The A122 (Lower Thames Crossing) Development Consent Order

CAH3 – written submission of oral comments made at the hearings held 17 Oct 2023

Tarmac Site Map

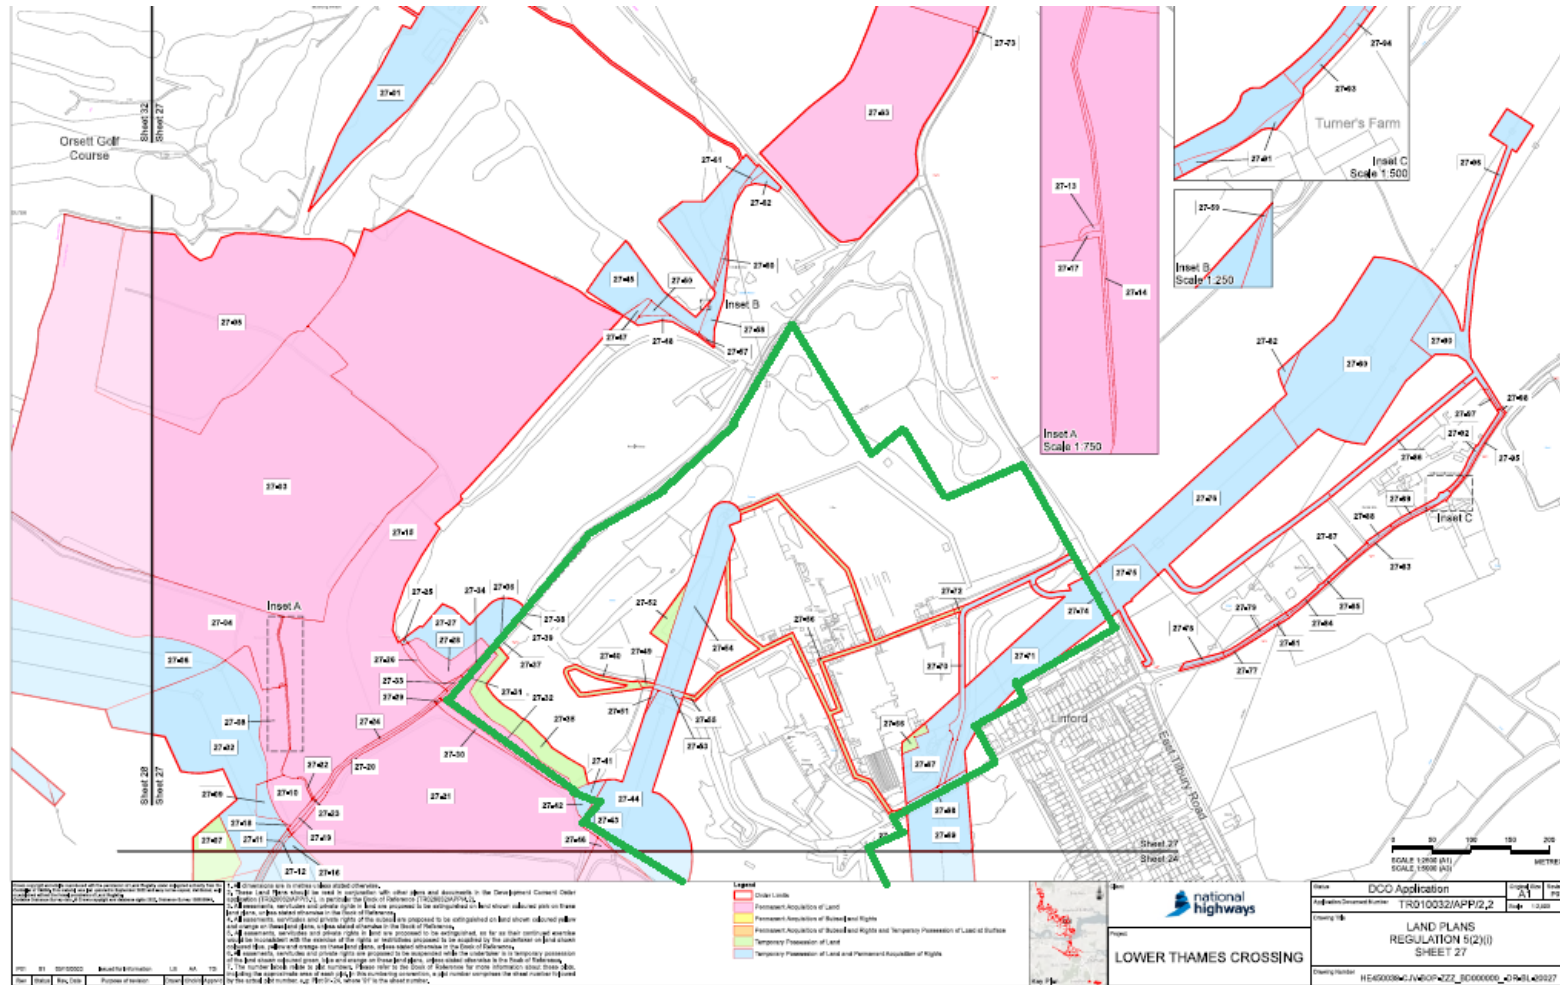
- 2.1. Tarmac's site consists of an 85 acre manufacturing site. The site is a major strategic concrete block manufacturing plant where Tarmac produce about 1.7 million blocks per month which are then nationally distributed for use in the construction industry. The site employs about 120 full time employees. There are two production factory buildings on site which can be in operation 24 / 7, depending on market demand. There are also various large stacking yards for raw materials, finished product and for damaged product to be stored ahead of crushing either recycled or landfilled. It is a busy site with manufacturing processes ongoing.

- 2.3. There are two overhead power lines operated by UKPN and National Grid who both also have pylons on the Tarmac's site: UKPN have pylon numbers PAB18 and PAB19 and National Grid have pylon ZJ016.
